PORTLAND MAINE

September 20, 2007

RE: Portland Inn, 1150 Brighton Avenue – 265 B005 – B2 – establish use of building – permit #07-1006

200 Front Desk

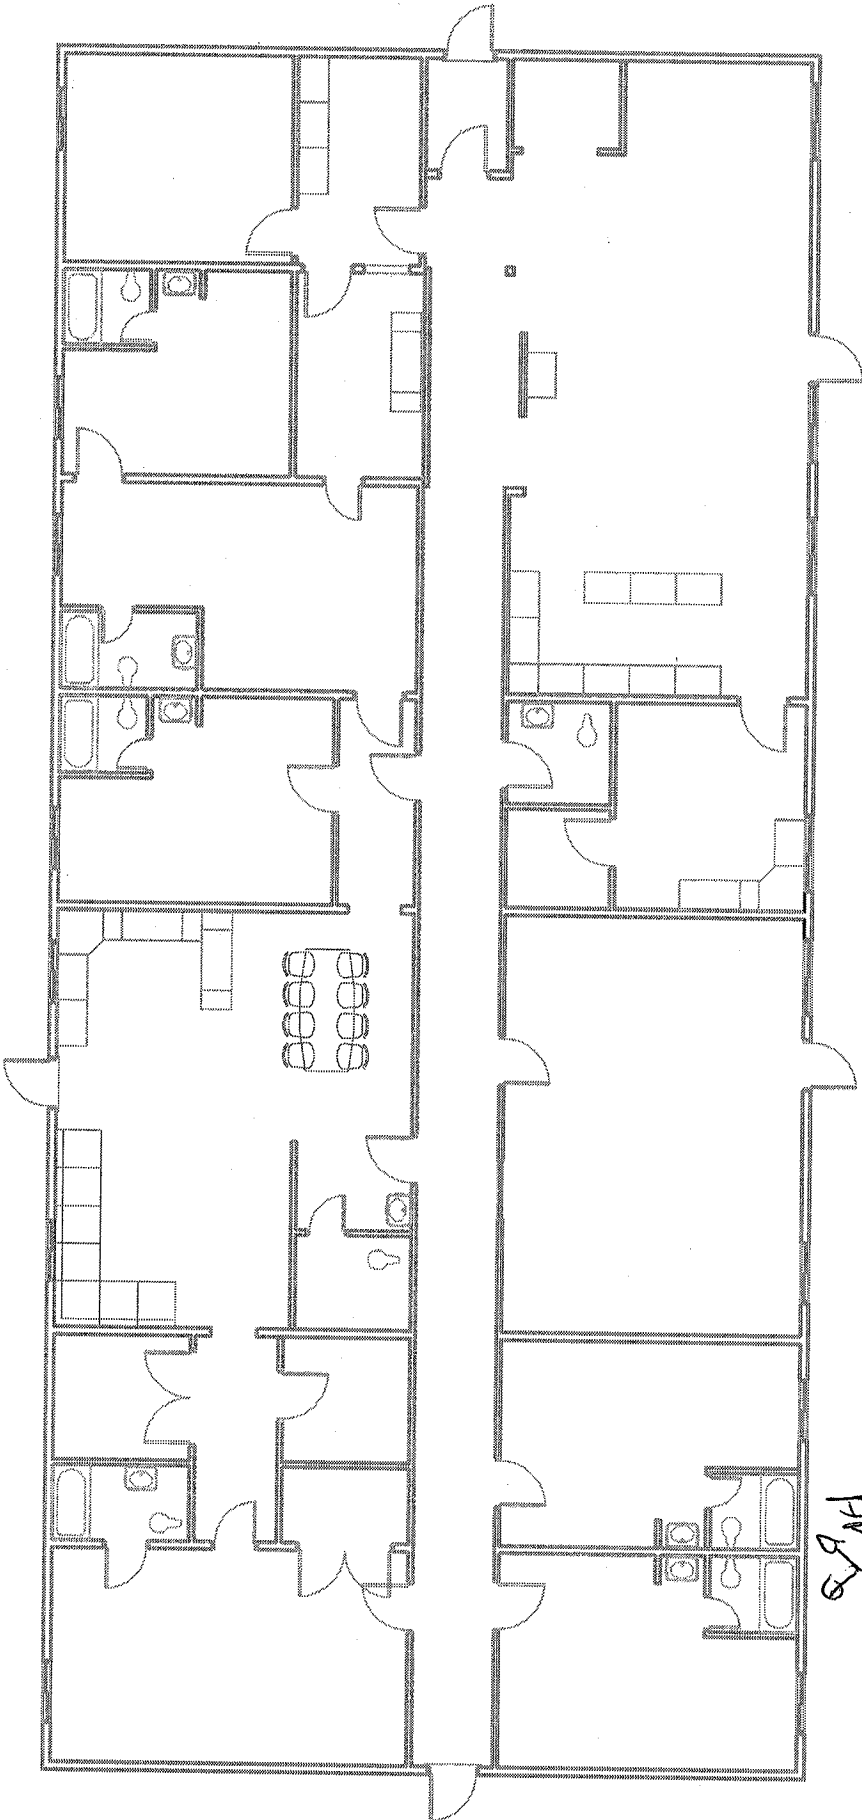
Part of the purpose of this permit is to establish the exact use of the building. We need a cover letter from you explaining exactly how the building is being used. In this letter when you talk about the food service component, you need to include exactly what is being served. You also need to submit a new floor plan that shows where the two sinks and refrigerator for the food prep is being located. The floor plan should also label how each space is being used. You may have one bed in the bedroom indicated on the plan if you install the egress window, but you must make it clear that the room will only include one bed.
